DEVELOPMENT REVIEW BOARD
UTILITY DEVELOPMENT
Standard Comment Sheet

DRB-1004555

**Development Review Board 12/7/05 Agenda Item #16
Sketch Plat: Lot 3, Block 31, Huning Highland Addition**

RE: Hunings Highlands Addition/sketch

**SKETCH PLAT OF
 LOTS 3-A & 3-B, BLOCK 31
 HUNING'S HIGHLAND ADDITION
 PROJECTED SECTION 20, T. 10 N., R. 3 E., N.M.P.M.
 TOWN OF ALBUQUERQUE GRANT
 CITY OF ALBUQUERQUE
 BERNALILLO COUNTY, NEW MEXICO
 NOVEMBER 2005**

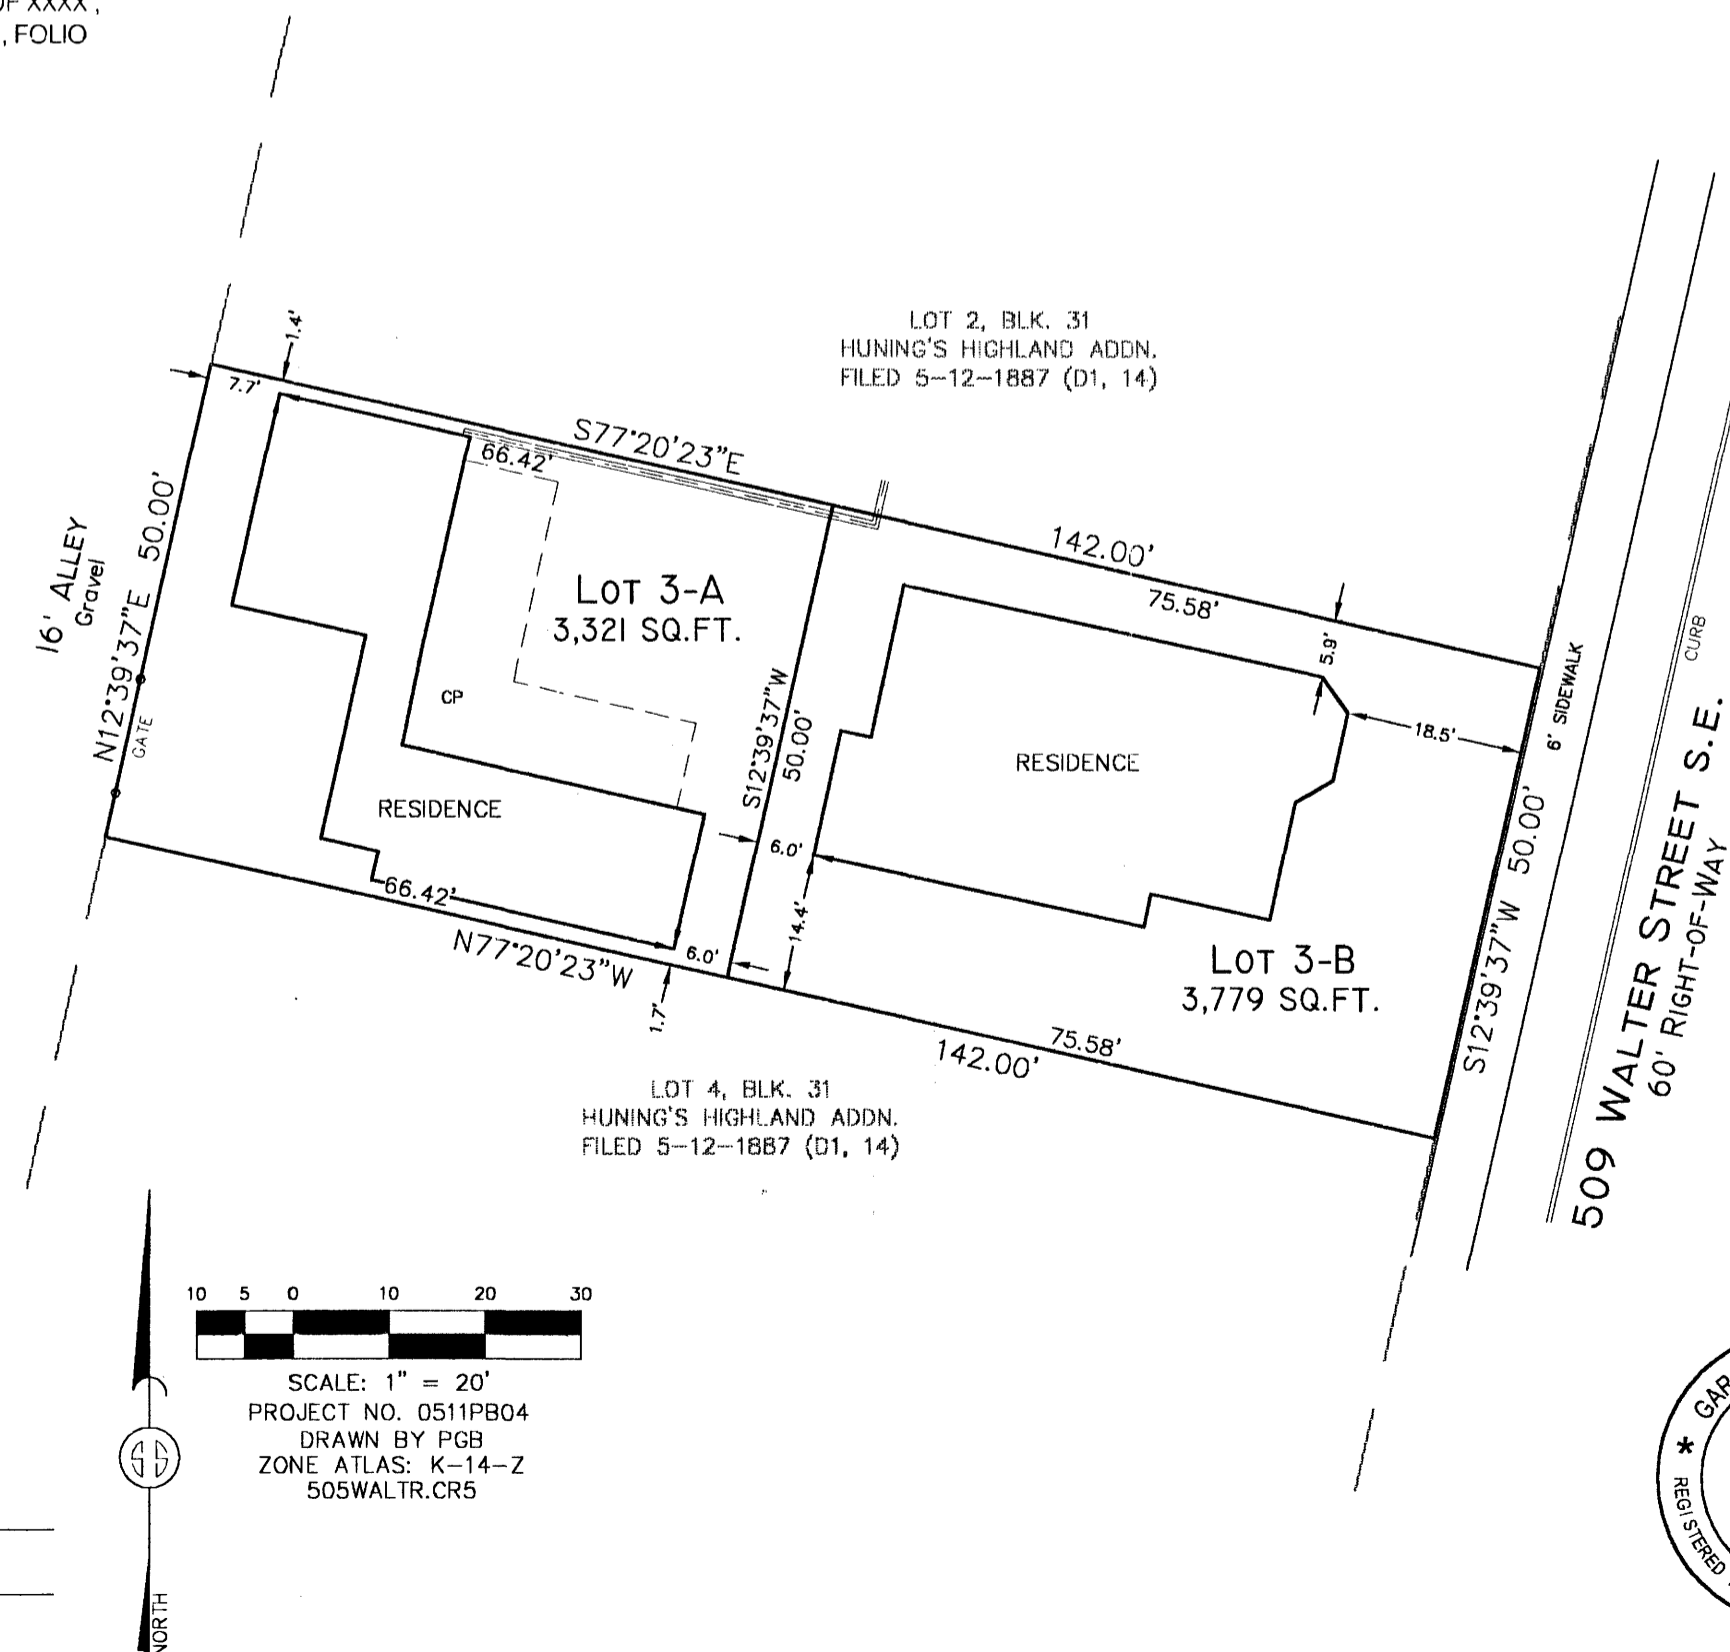
1. This lot split will not work as there is no sanitary sewer line in Walter to provide service to the east lot. There is no room to construct a service line to the alley where the sewer line is located.

Need cross-lot drainage easement.

Where is the existing residence access from Walter to the new lot?
